Luckington and Alderton Parish Council request that the Planning Inspectorate Examining Authority accept this response to the applicant's (Lime Down Solar Park) Change Application (June 26). PI Ref: EN0101168 Document Reference EXAM / 9.40

Luckington and Alderton Parish Council.

20th August 2026

Title:
Figure 2-2-1: Field Boundaries and Numbering
Lime Down A

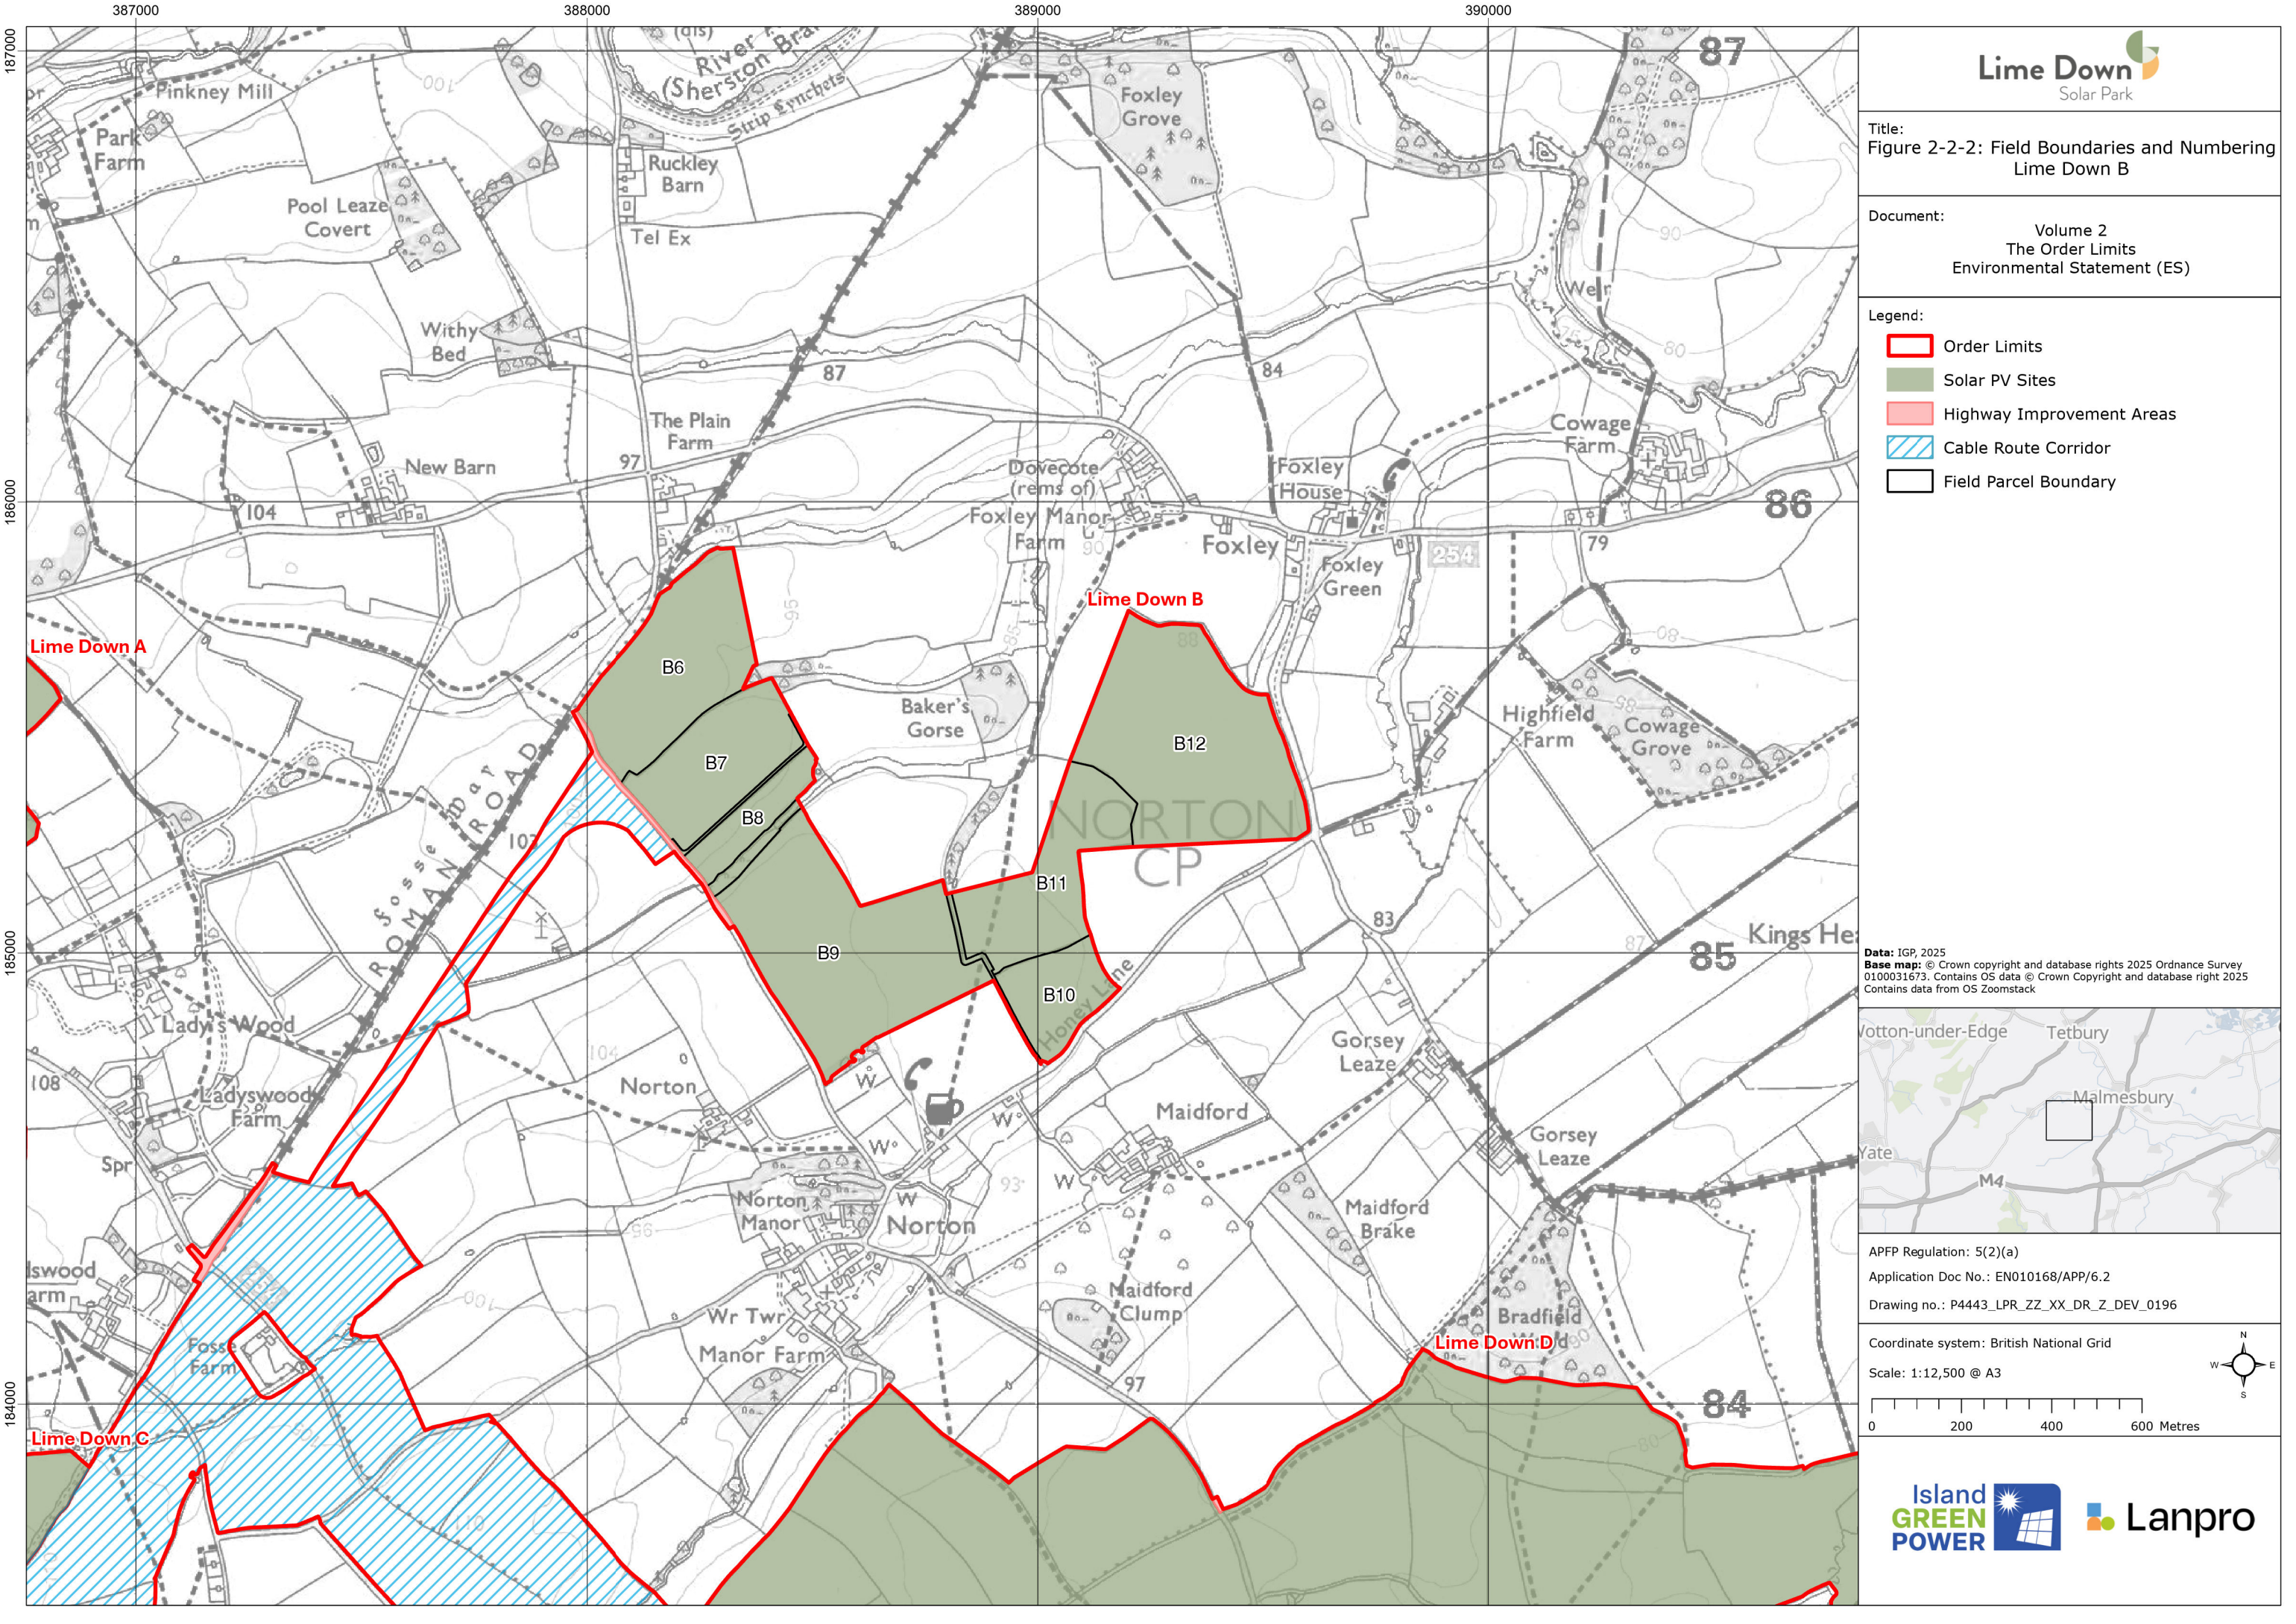
The changes proposed within »Change.9« is in our view a significant change within the Lime Down »A" area and does have significant implications as instead of solely hosting panels and their limited infrastructure the new proposal indicates that substantial below ground and potential above ground infrastructure could now be located within the Lime Down »A" area. This brings this more substantial solar infrastructure much closer to the houses in and around Alderton than was previously planned and represents a more worrying and intrusive proposal than that which the local community were previously consulted on;

The changes proposed within "Change 3" is, in our view, a significant change within the Lime Down 'A' area and does have significant implications, as instead of solely hosting panels and their limited infrastructure, the new proposal indicates that substantial below ground and potential above ground infrastructure could now be located within the Lime Down 'A' area. This brings this more substantial solar infrastructure much closer to the houses in and around Alderton than was previously planned and represents a more worrying and intrusive proposal than that which the local community were previously consulted on.

Some parts of Work Number 1(d) already include areas of Work Number 5B. This proposed change would update the Works Plans so that Work Number 5B is included across the full area of Work Number 1(d) within the relevant parts of Lime Down A, C and E.

This would provide more flexibility at the detailed design stage, when the precise alignment of the interconnecting cables is confirmed. The interconnecting cables are the cables that would connect different parts of the solar park, including the Conversion Units, 33 kV Sub-distribution Switch Rooms, 132 kV Substations, the 400 kV Substation and the Solar PV Sites.

Title:
Figure 2-2-3: Field Boundaries and Numbering
Lime Down C

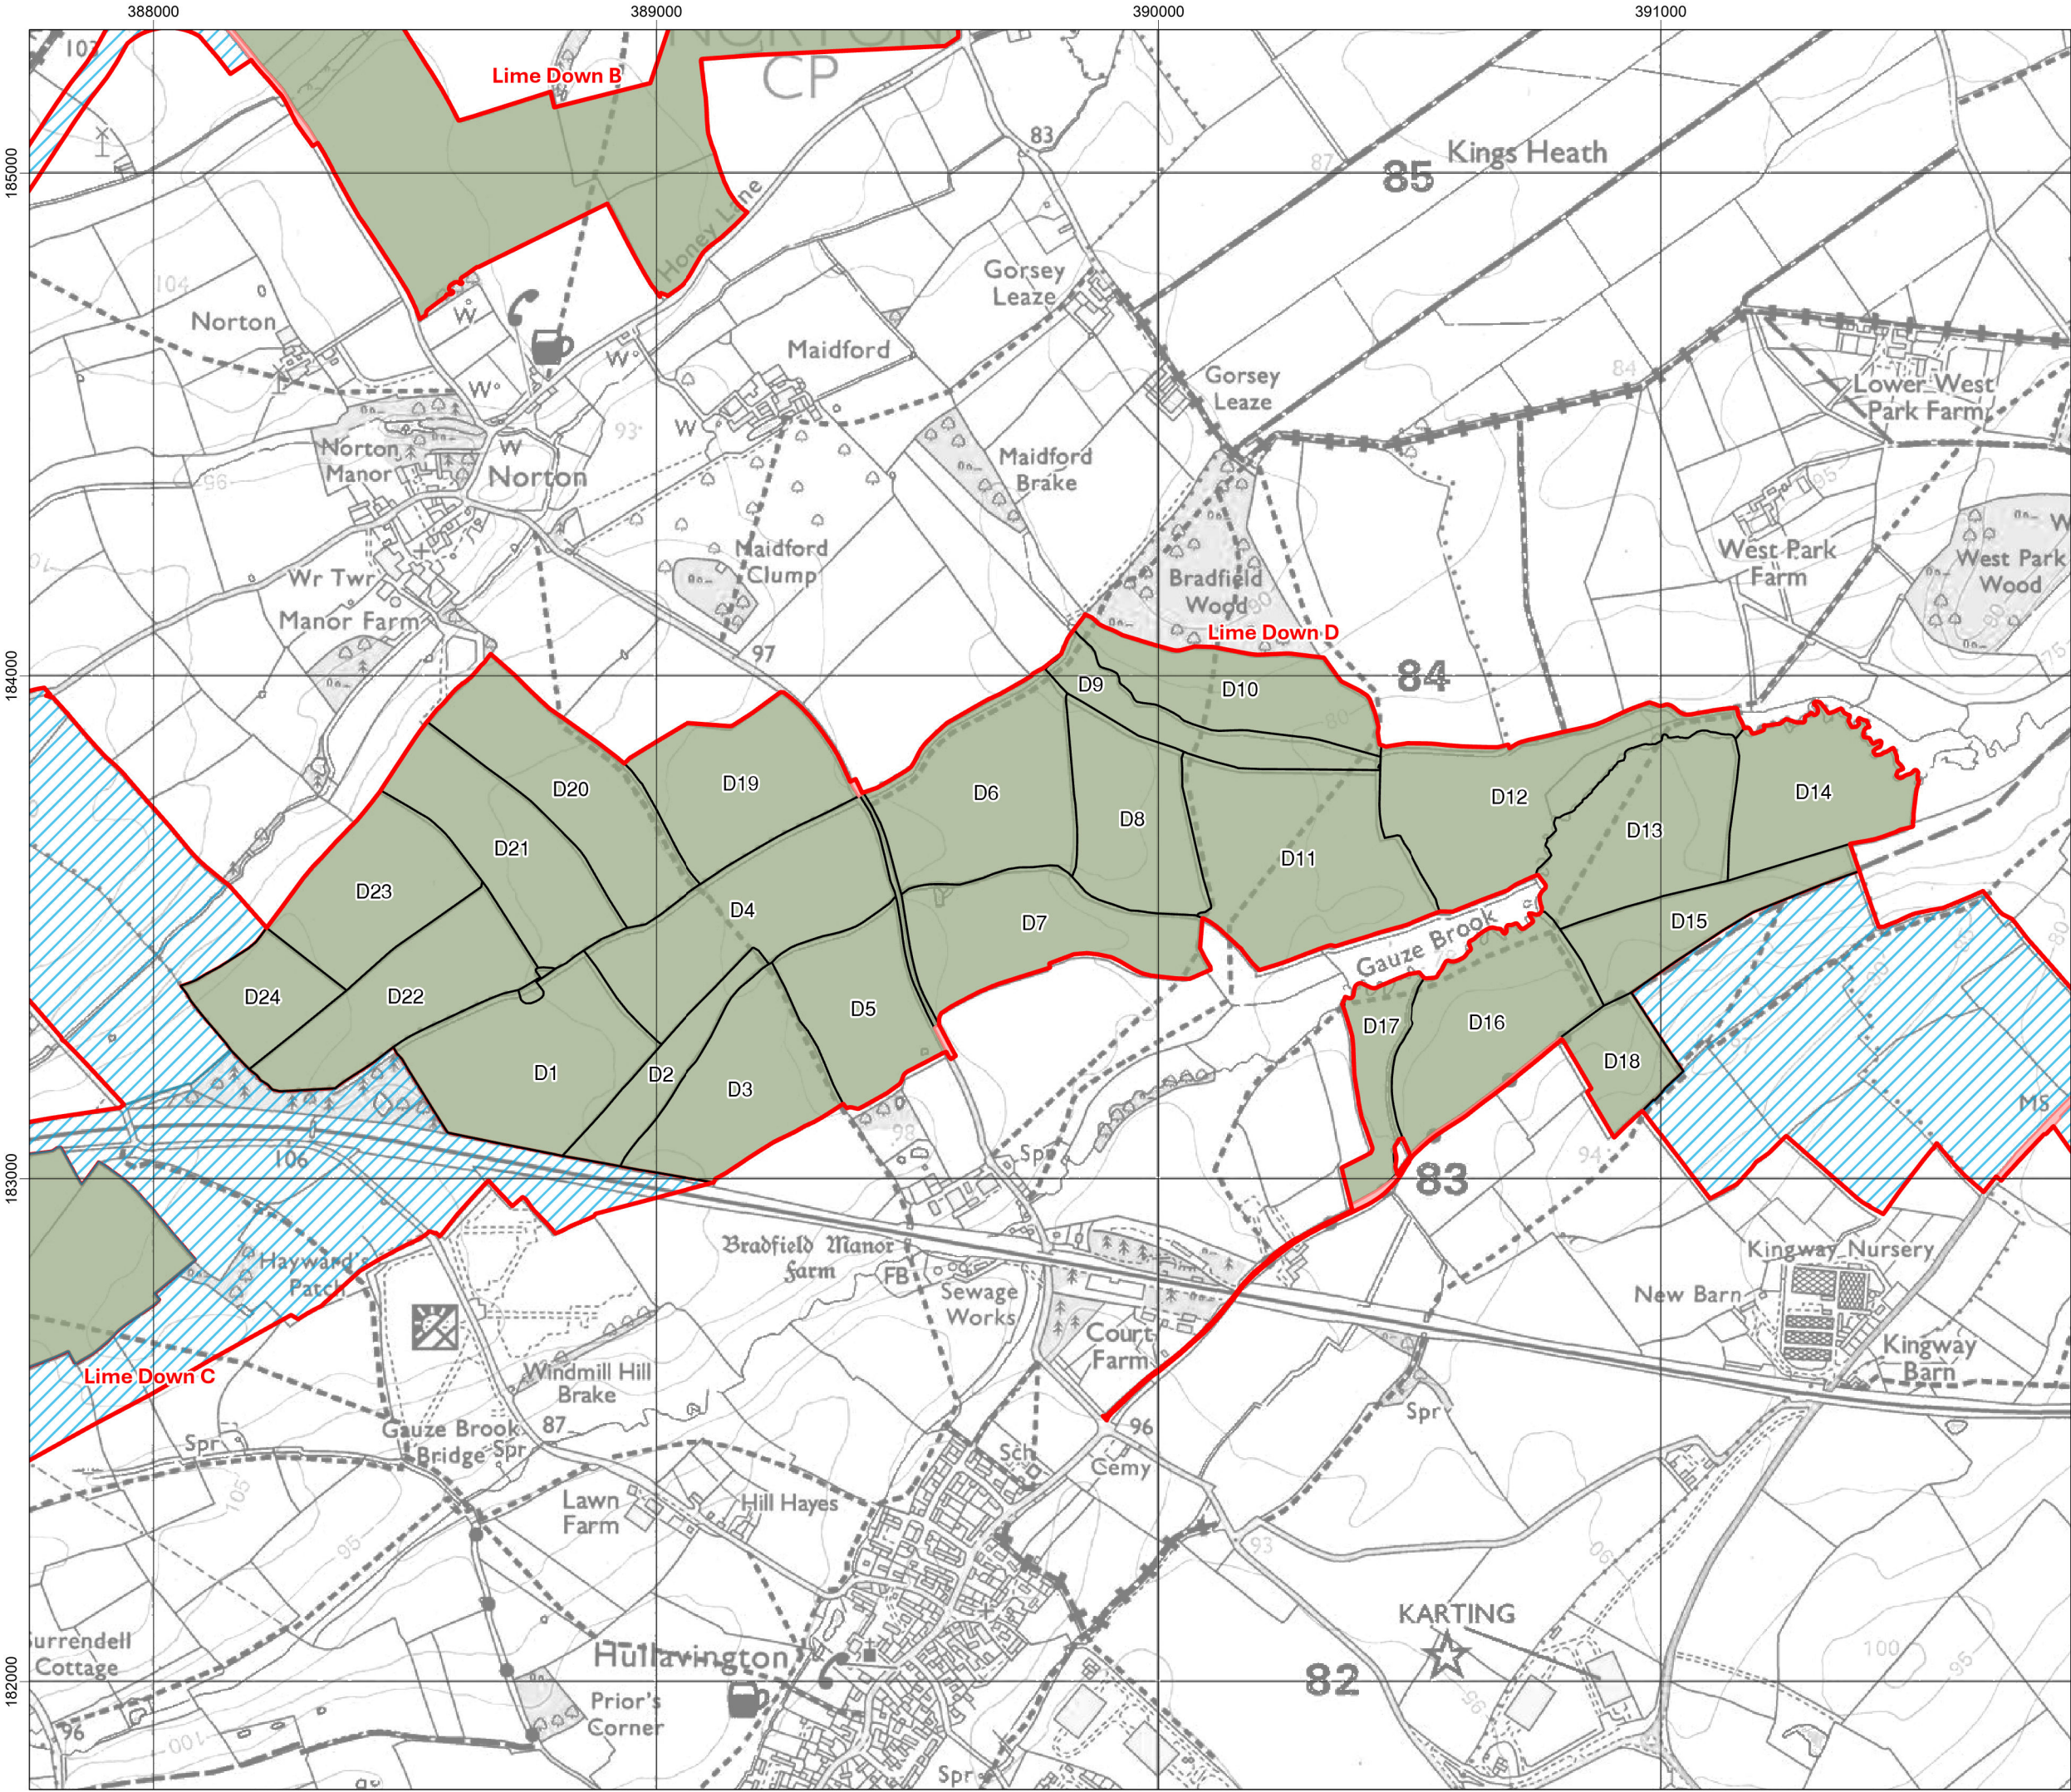
»Change.0« is confusing and requires more detailed explanation and additional information. It is unclear why that specific area is included or why you have drawn the boundaries where you have. There is almost identical landscape alongside it but this has been ignored and left outside the perimeter why? What is the rationale for this? We do support the removal of panels from this »visible" area but do not understand why it has been so limited and would advocate that a much larger area »visible" area around it with similar landscape characteristics should also be included in the »panel free" zone;

"Change 4" is confusing and requires more detailed explanation and additional information. It is unclear why that specific area is included, or why you have drawn the boundaries where you have. There is almost identical landscape alongside it, but this has been ignored and left outside the perimeter, why? What is the rationale for this? We do support the removal of panels from this 'visible' area, but do not understand why it has been so limited, and would advocate that a much larger area 'visible' area around it, with similar landscape characteristics, should also be included in the 'panel free' zone.

This proposed change relates to Field C9 at Lime Down C. Following ongoing engagement with the Cotswolds National Landscape Board, we are proposing to remove solar infrastructure from this field.

This change responds to feedback about how the solar infrastructure could be seen from receptors located on Alderton Road. It would reduce the amount of solar infrastructure proposed in this part of Lime Down C and help reduce potential visual impacts in this location.
